# **Deadline 7 Submission on Behalf of the Neighbours and Users of Queen Elizabeth Park**

Interested Party reference no: **20022545**

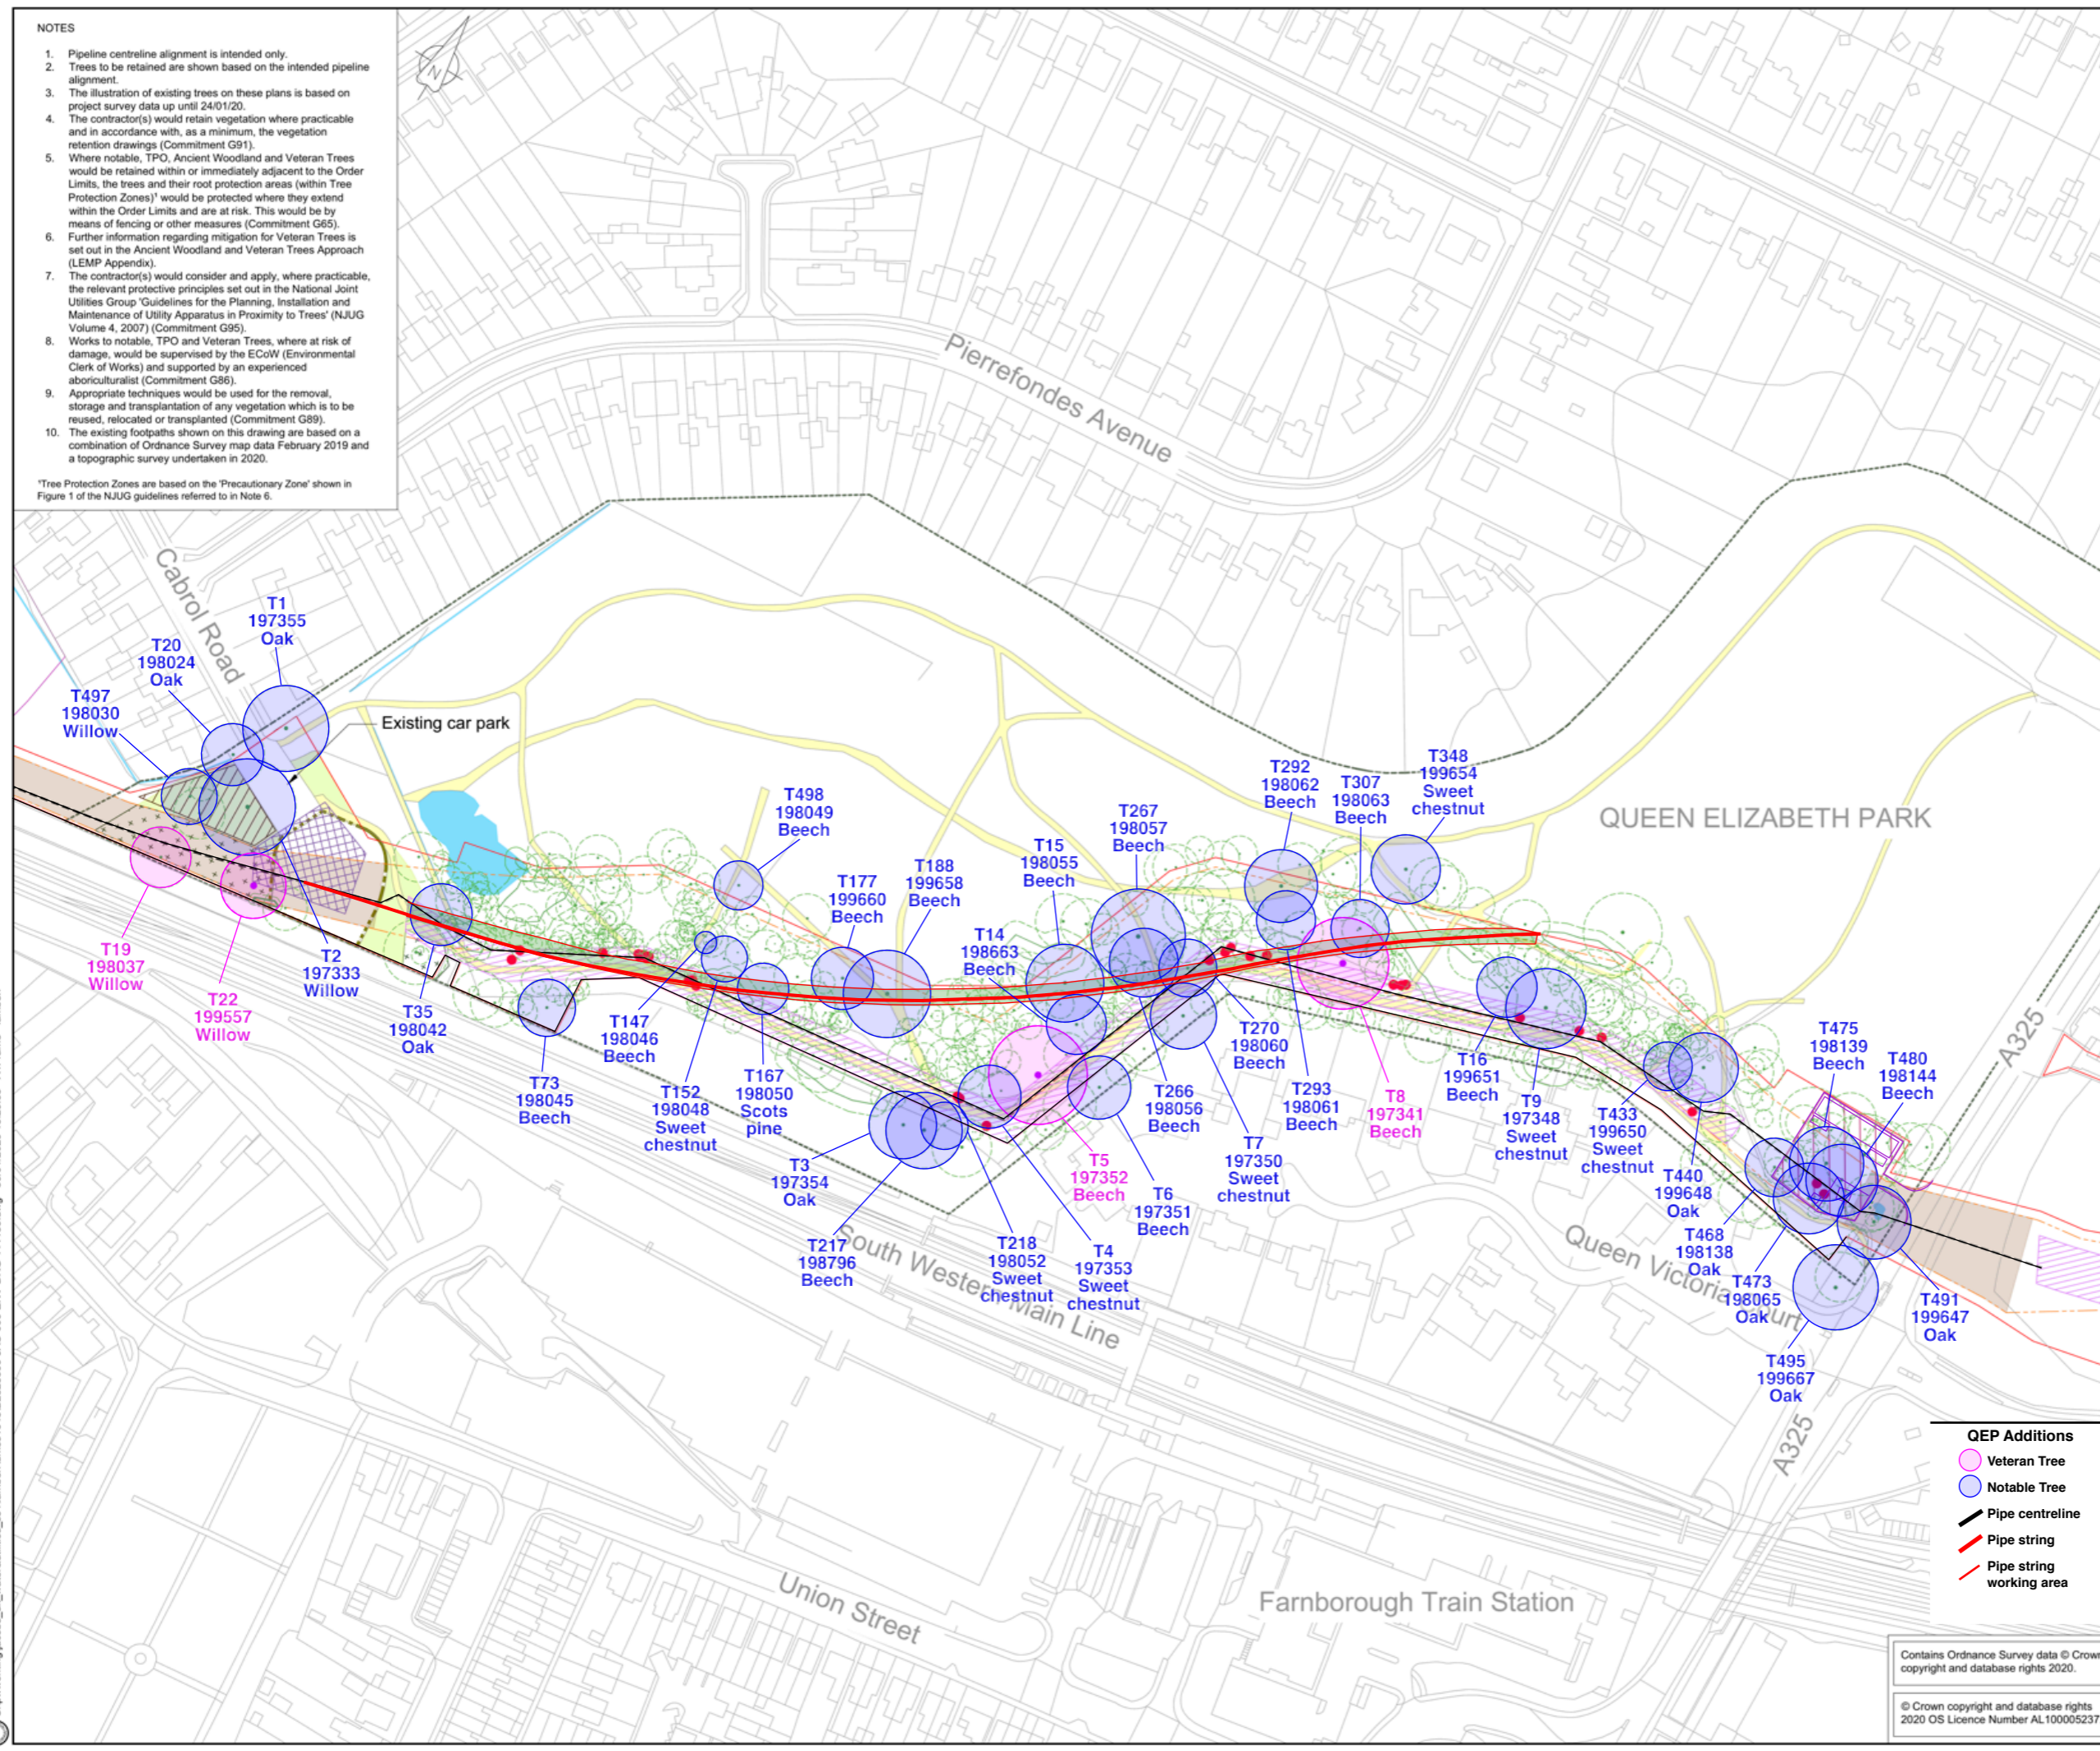
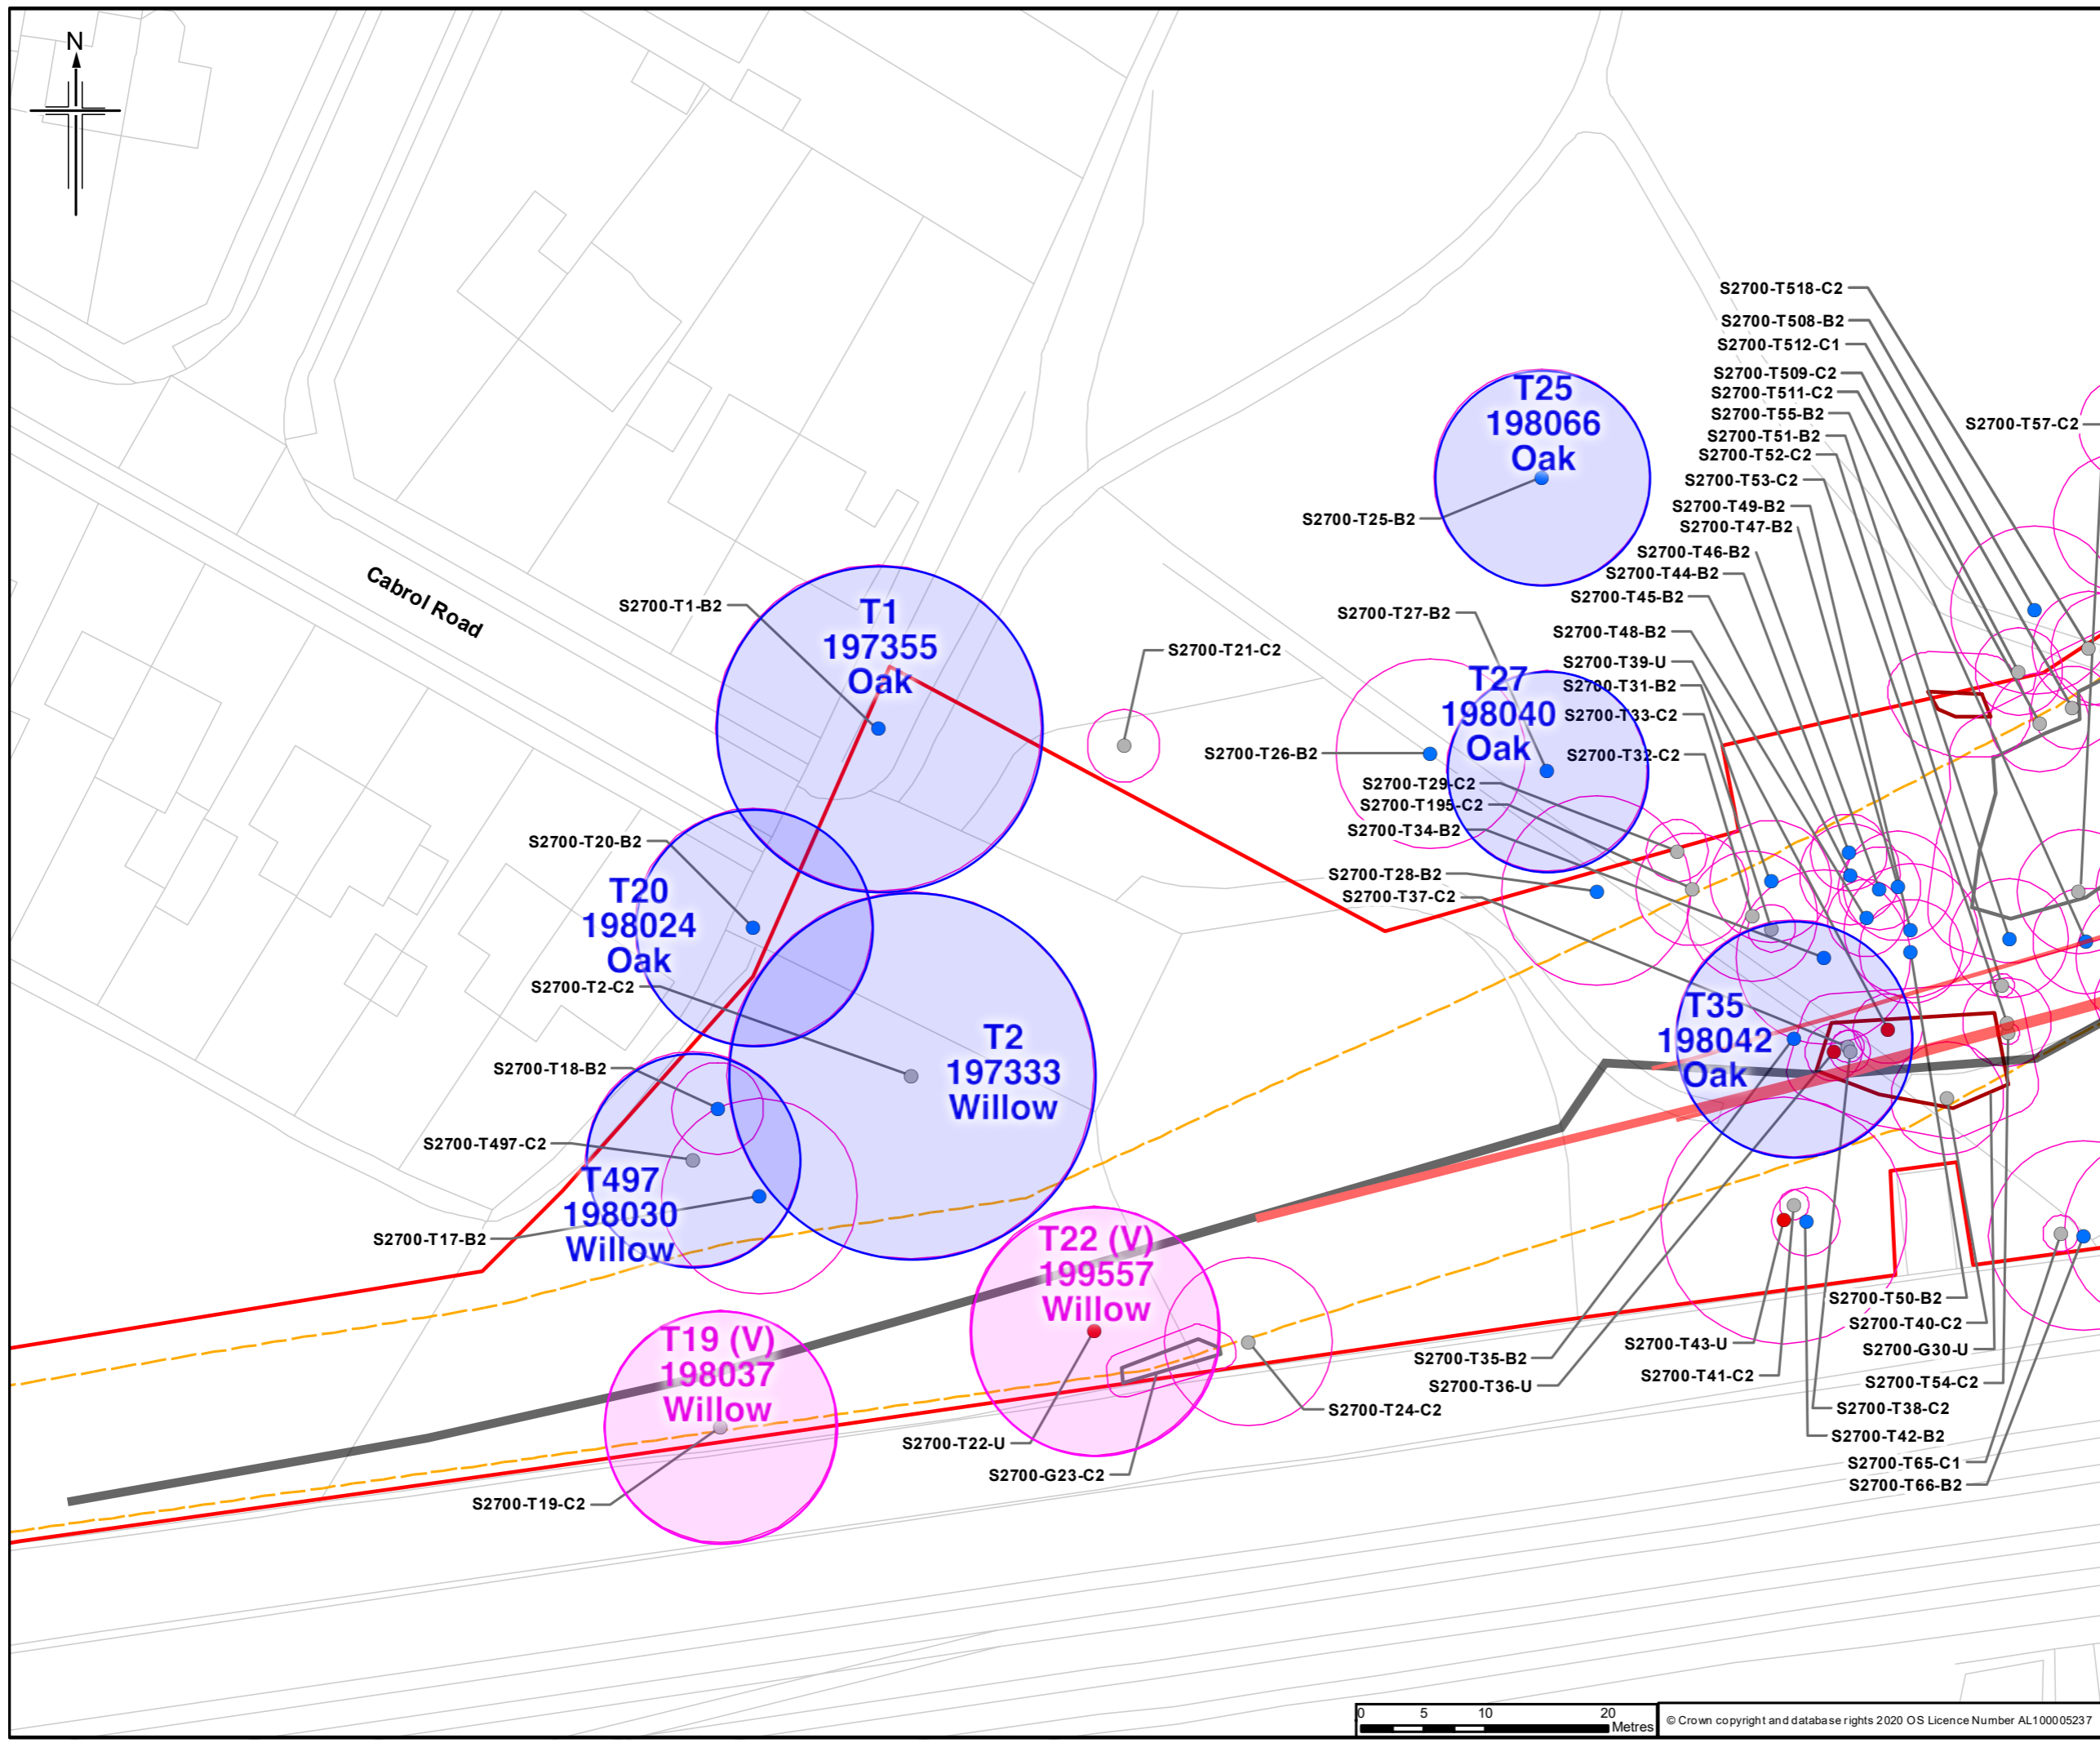
Corrected tree positions: T562 (sycamore), T487 (beech) and T489 (beech) are not correctly located on Esso's map. Dotted orange lines show the position on Esso's tree survey, solid orange lines show roughly where the trees actually are.

We also note that the drawings and tree survey in the SSP continue to feature the following errors:

1. Missing Notable Tree in the Cabrol Road compound area
2. Oak tree misclassified as sweet chestnut
3. Trees in the working area shown on the wrong side of the path
4. The 'pond' by the A325 is drawn in the wrong position
